From: Michael Eastham
Sent: 13 November 2017 20:36
To: Fiona Fitzgerald
Subject: FW: BE/102/17/OUT

Further to the comments/queries raised by the EHO, please see comments in red below and attached.

From: Fiona Fitzgerald
Sent: 08 November 2017 14:19
To: Planning.Responses
Cc: Michael Eastham
Subject: BE/102/17/OUT

1A: No Mitigation L_{Aeq}

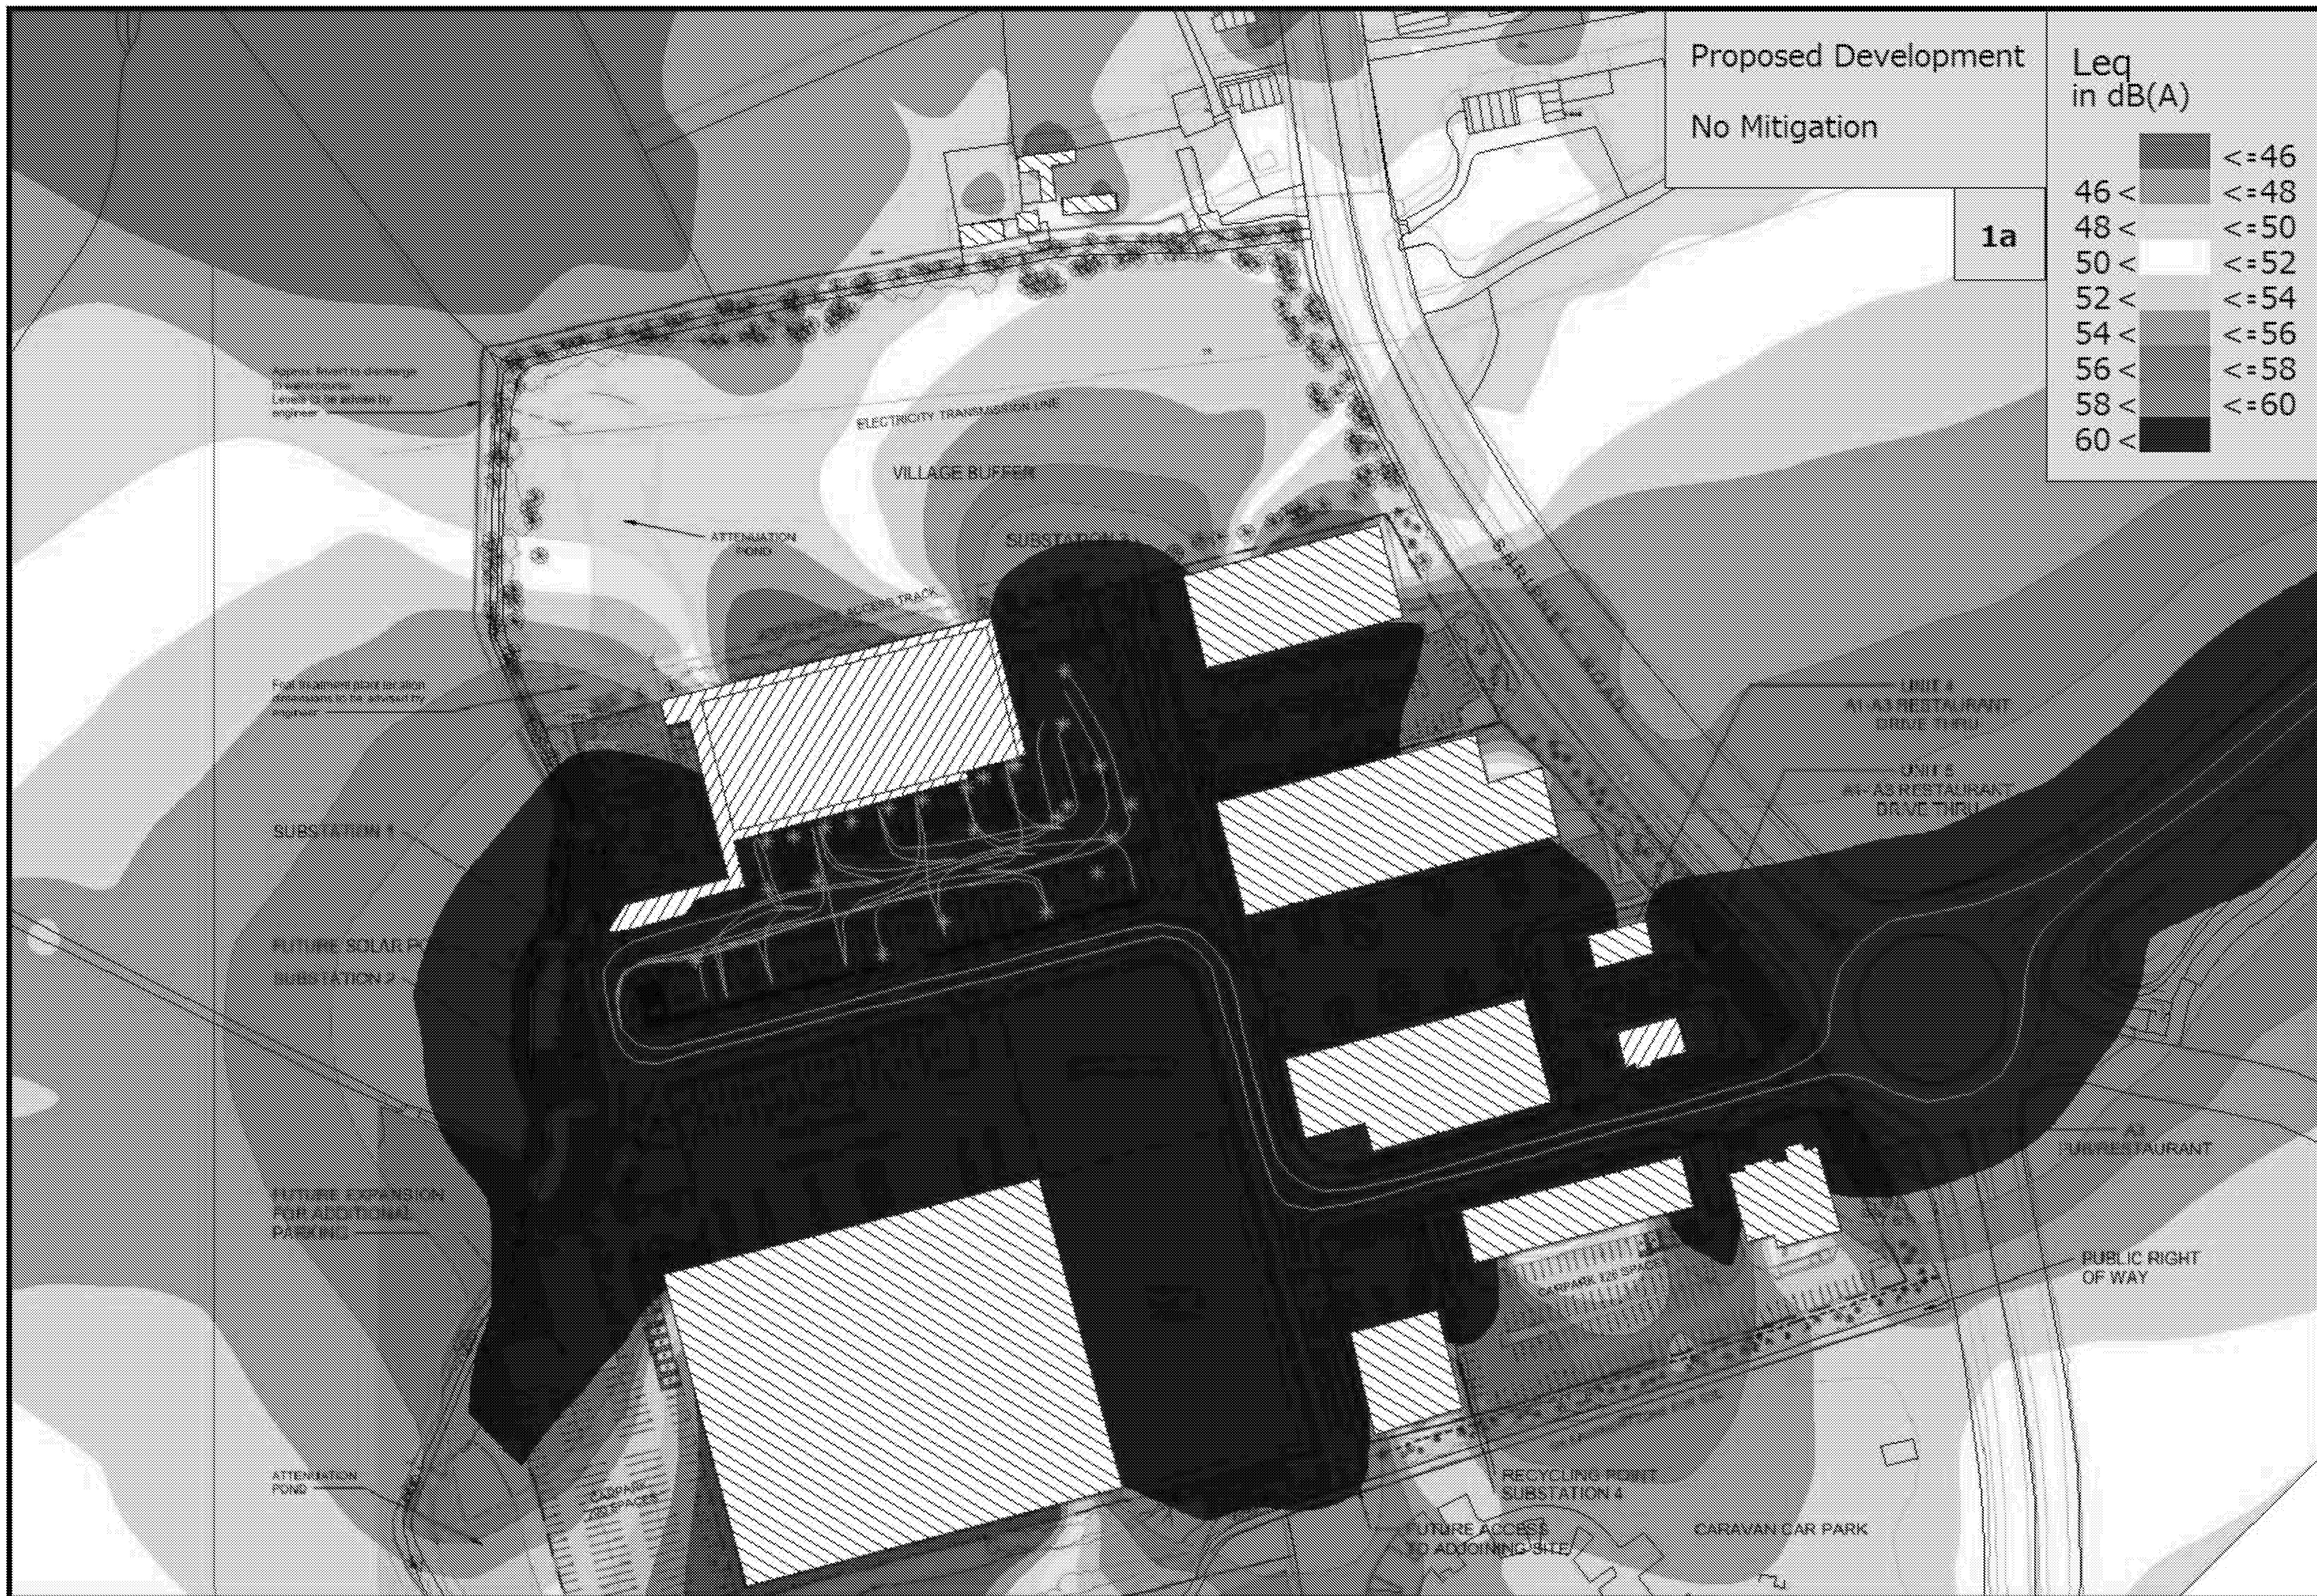
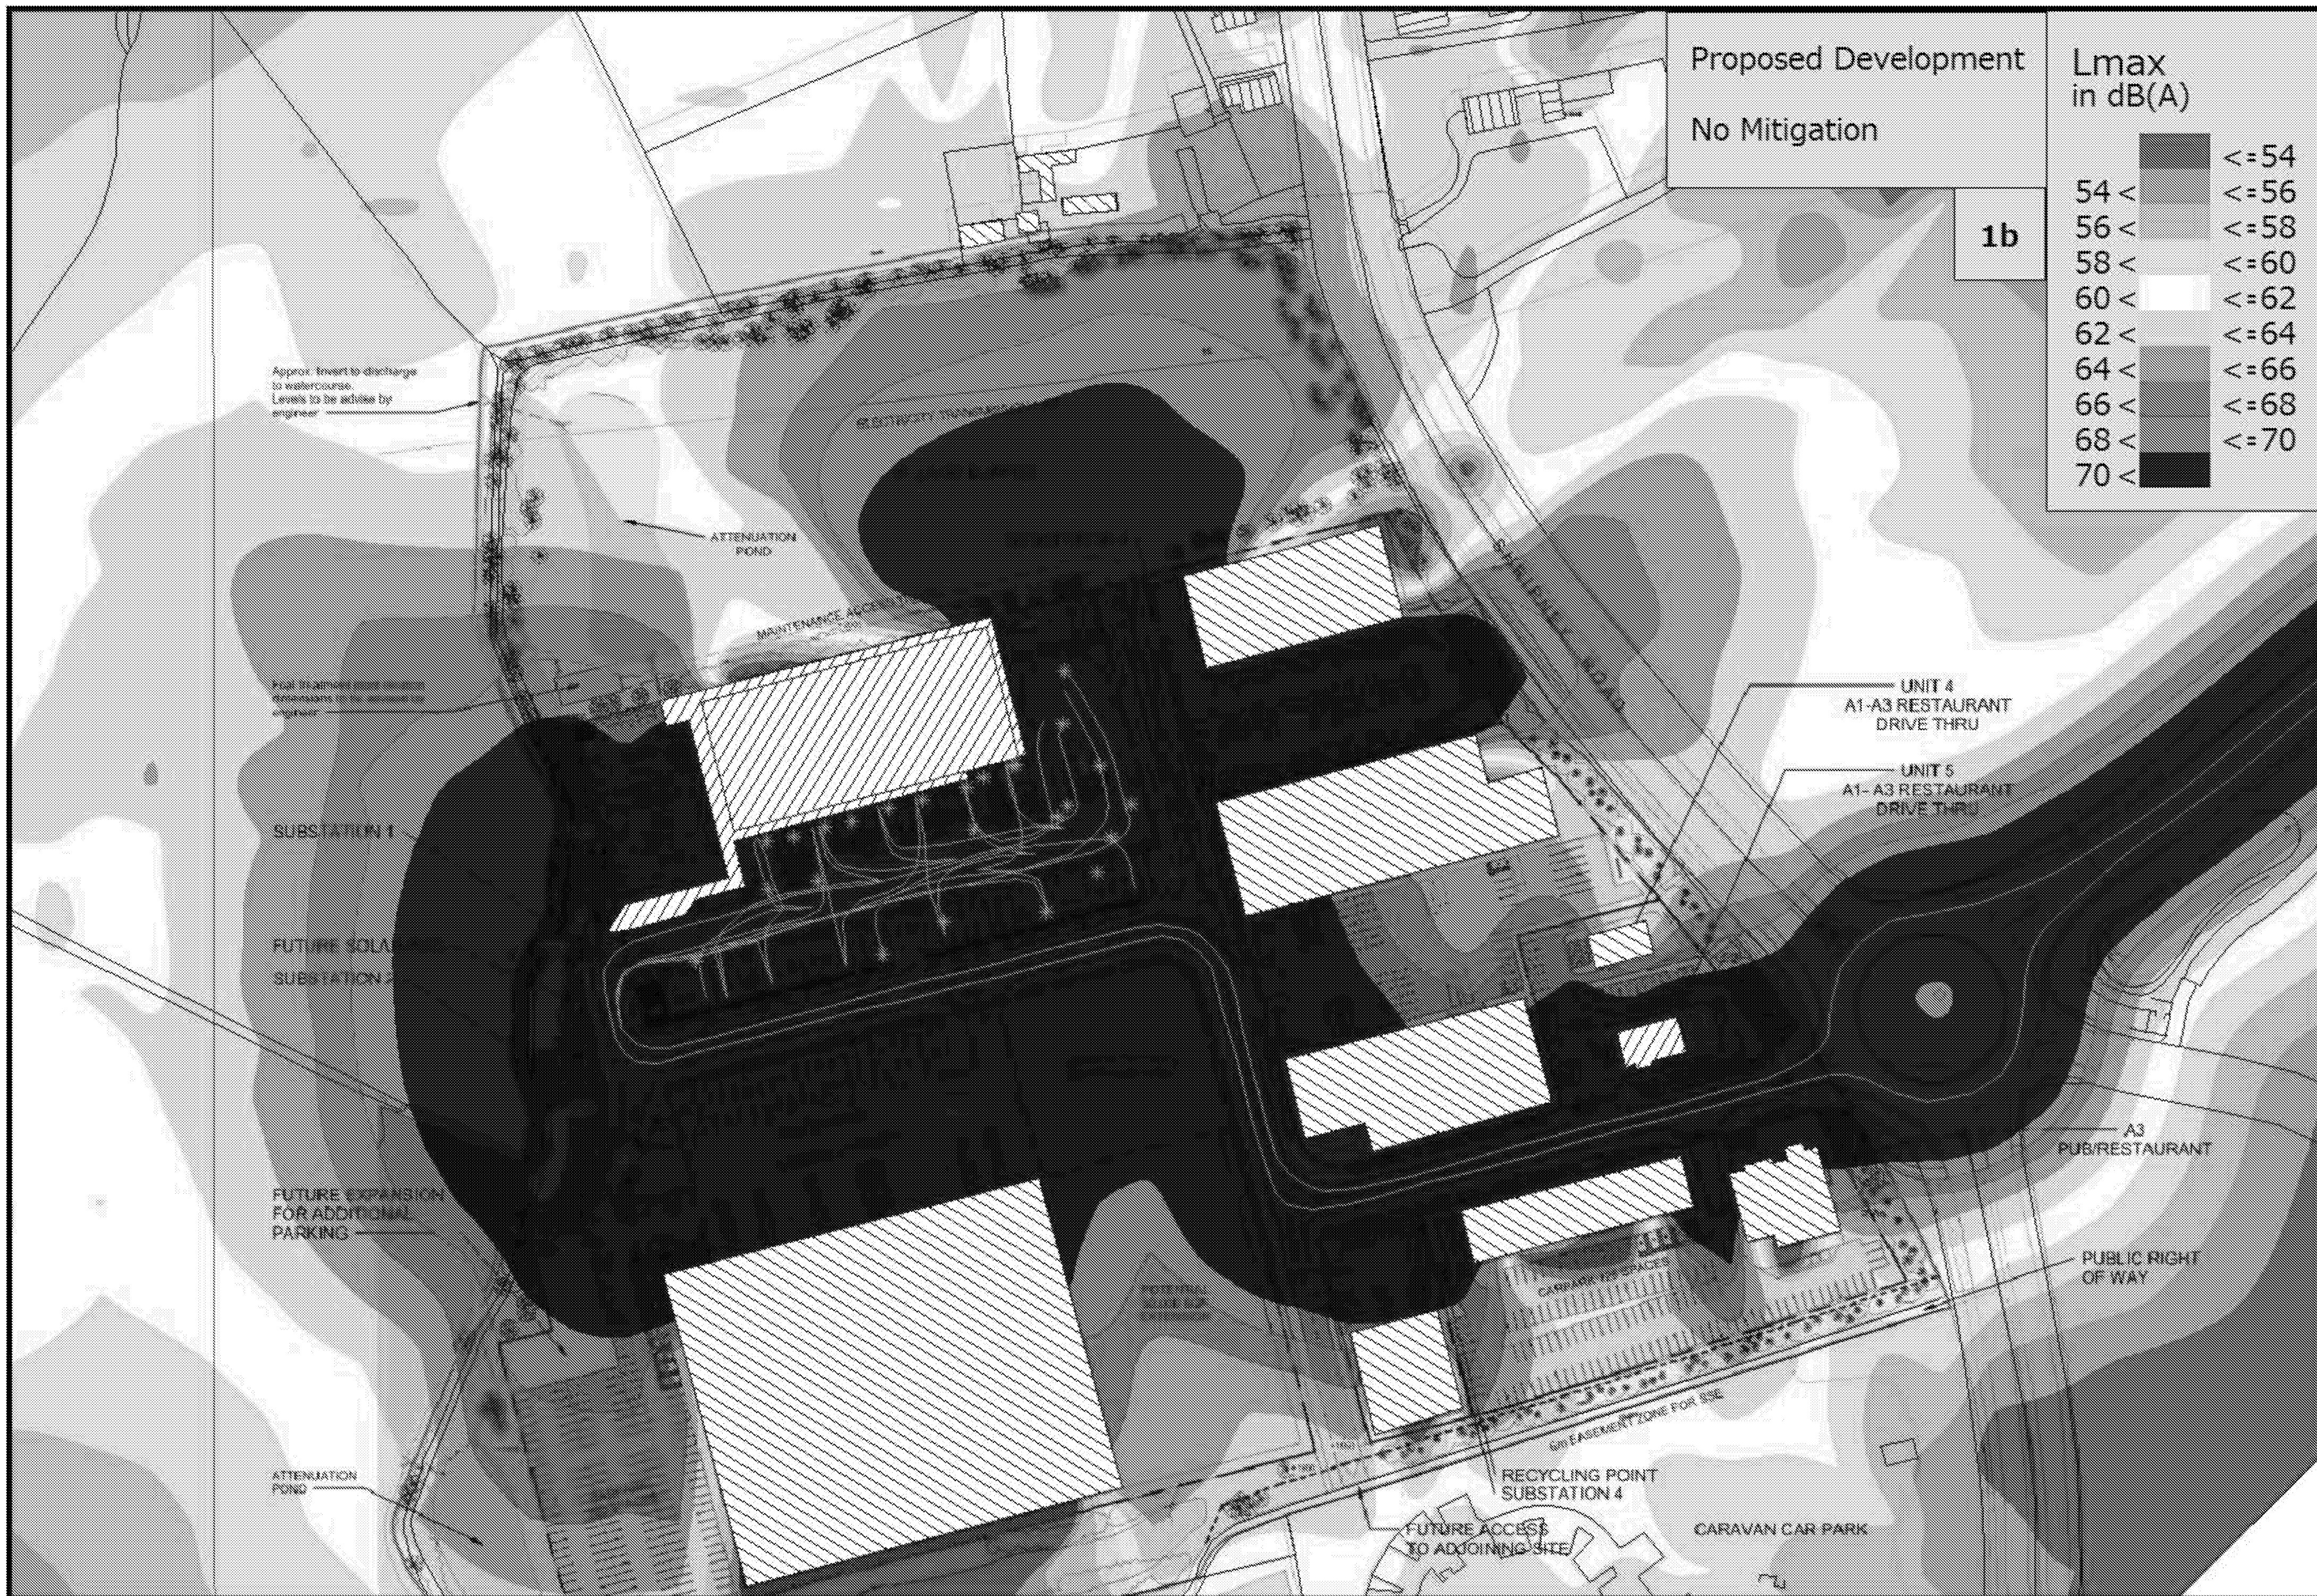
1. The report only deals with noise in detail for Unit 2 and whilst I understand this because the application is for full permission for Unit 2 and outline for the rest of this site, I have concerns that there may be cumulative noise impacts as unit 1, 3, 6 and 7 also either be B1/B8 use and they may have associated HGV movements. I am concerned that any cumulative noise impacts have not been taken into account at this stage and wants out my permission has been given may not be fully resolvable at that point. But the applicant confirm whether they have taken this into account or not?

4. Paragraph 4.5 on page 12, just to clarify, “all loading bays“ means all loading bays in unit two presumably?

Unit 2 was assessed as the only full application. There is no detail relating to the future use of other units, although the assessment was modelled using worst case of all loading bays being operated simultaneously. Any future HGV movements across the site would need to double to give a 3dB increase. Even with this unlikely level of activity the L_{Aeq} levels at the nearest residential property to the north would be in the region of 51dB and still be within desirable WHO guidelines for external noise. Any L_{Amax} levels would be consistent with predictions.

All loading bays in Unit 2
